**CITY OF ALBUQUERQUE
PLANNING DEPARTMENT
February 25, 2015
DRB Comments**

PROJECT # 1004310

APPLICATION # 15-70071

RE: Lot 7, Block 13, Volcano Cliffs Unit 3

CONCEPTUAL SITE PLAN

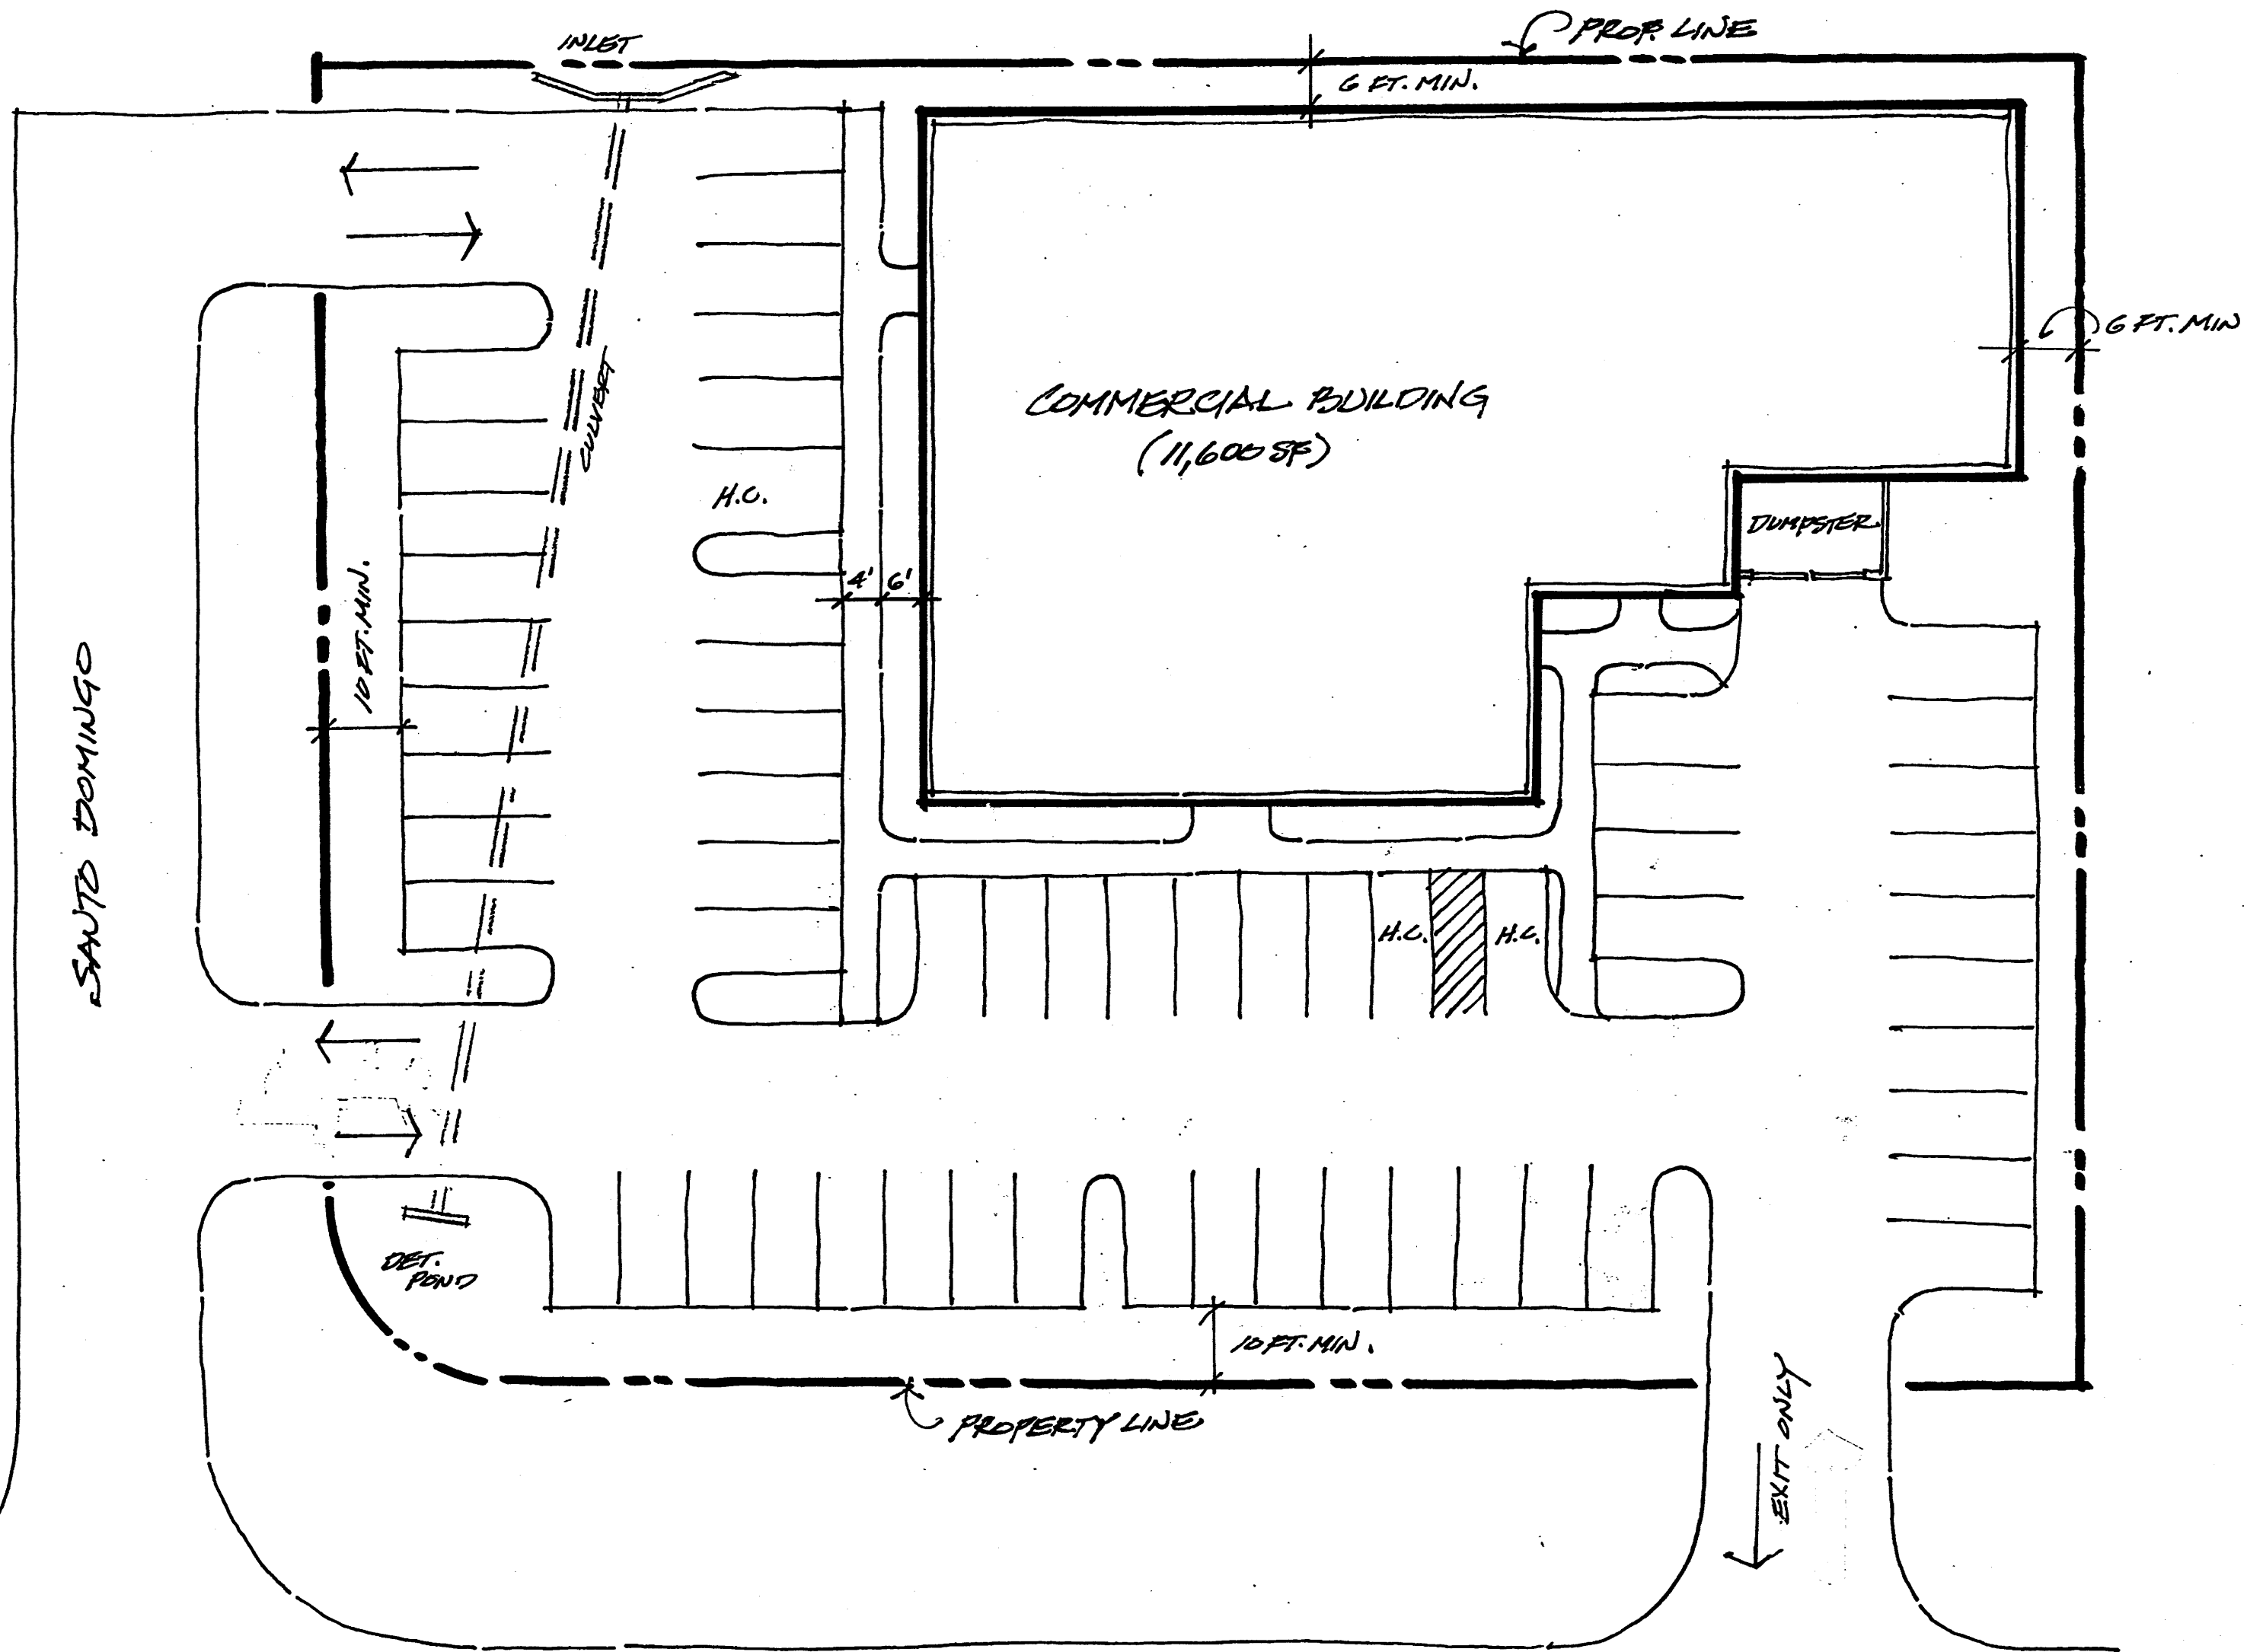
Regarding question 5, parking requirements are established by
Zoning Code §14-16-3-1; it appears required parking would be 58
spaces if net leasable area is 11,600 sq ft (vs 12,000). A parking
variance would be a form of Special Exception that could be applied
for under §14-16-4-2 of the Code.

Regarding question 6, *on-site signage is regulated in the O-1 district
of the Zoning Code §14-16-2-15(A)(16) and supplemental regulations in
§14-16-3-5 of the Code. Off-site (or 'billboard') signage is not allowed
in the O-1 zone. A cell tower is classified as a Wireless Transmission
Facility and is regulated by §14-16-3-17 of the Code.*

Regarding question 7, this site is within two planning areas that
modify and are in addition to the Zoning Code regulations: the Impact
Area of the Northwest Mesa Escarpment Plan (NWMEP) and the
Unser Boulevard Design Overlay Zone. Most significant is the Impact
Area of the NWMEP has a maximum height regulation of 15 feet
above existing grade (up to 19 feet with justification).
